From: Nicola Spencer
Sent: 27 April 2017 09:43
To: [REDACTED]
Subject: RE: Further Information Required on Your Ref: N/A Our Ref: BE/41/17/HH

Location Plan scale 1 : 1250

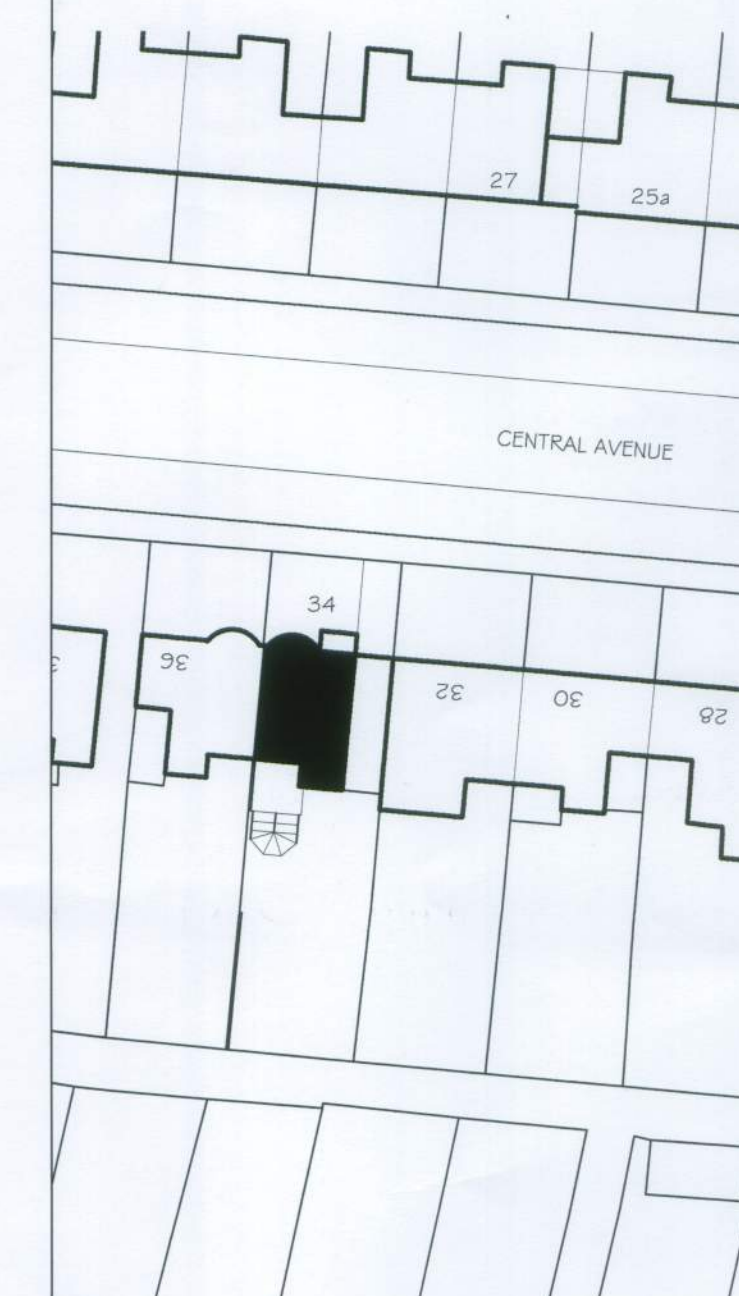
The copy that was scanned had not been red edged but I have arranged for the colour copy we have to be scanned, so this resolves the issue of the red edge on the location plan.

Site Plan scale 1 : 500

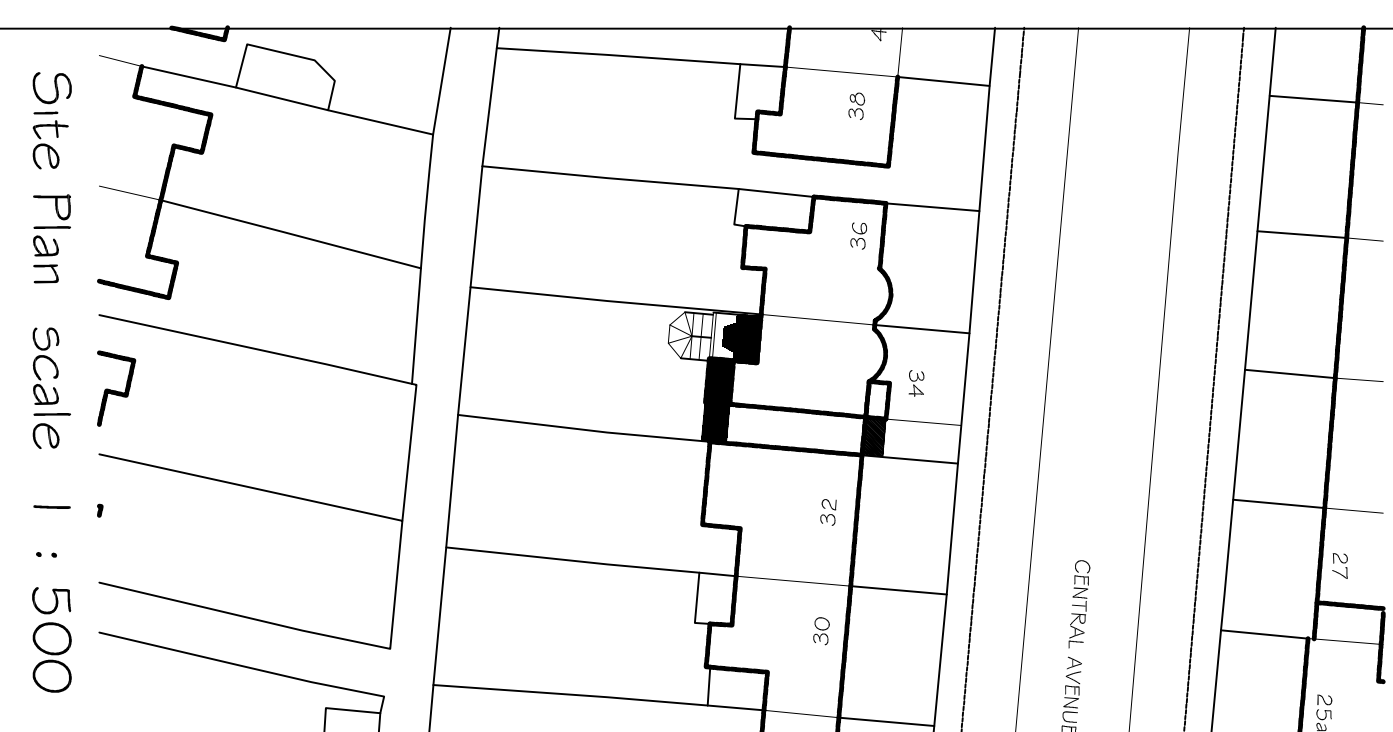
With regard to the distances to the boundary it appears that the ground floor extensions run up to the side boundary so I only require the distances from the proposed ground floor extension to the rear boundary and the distance between the proposed garage extension to the front boundary

On receipt of the amended block plan showing the dimensions to the boundaries we will be pleased to validate your application

Here attached revised drawing in PDF format, with dims for front and rear
Please confirm that this is what you require
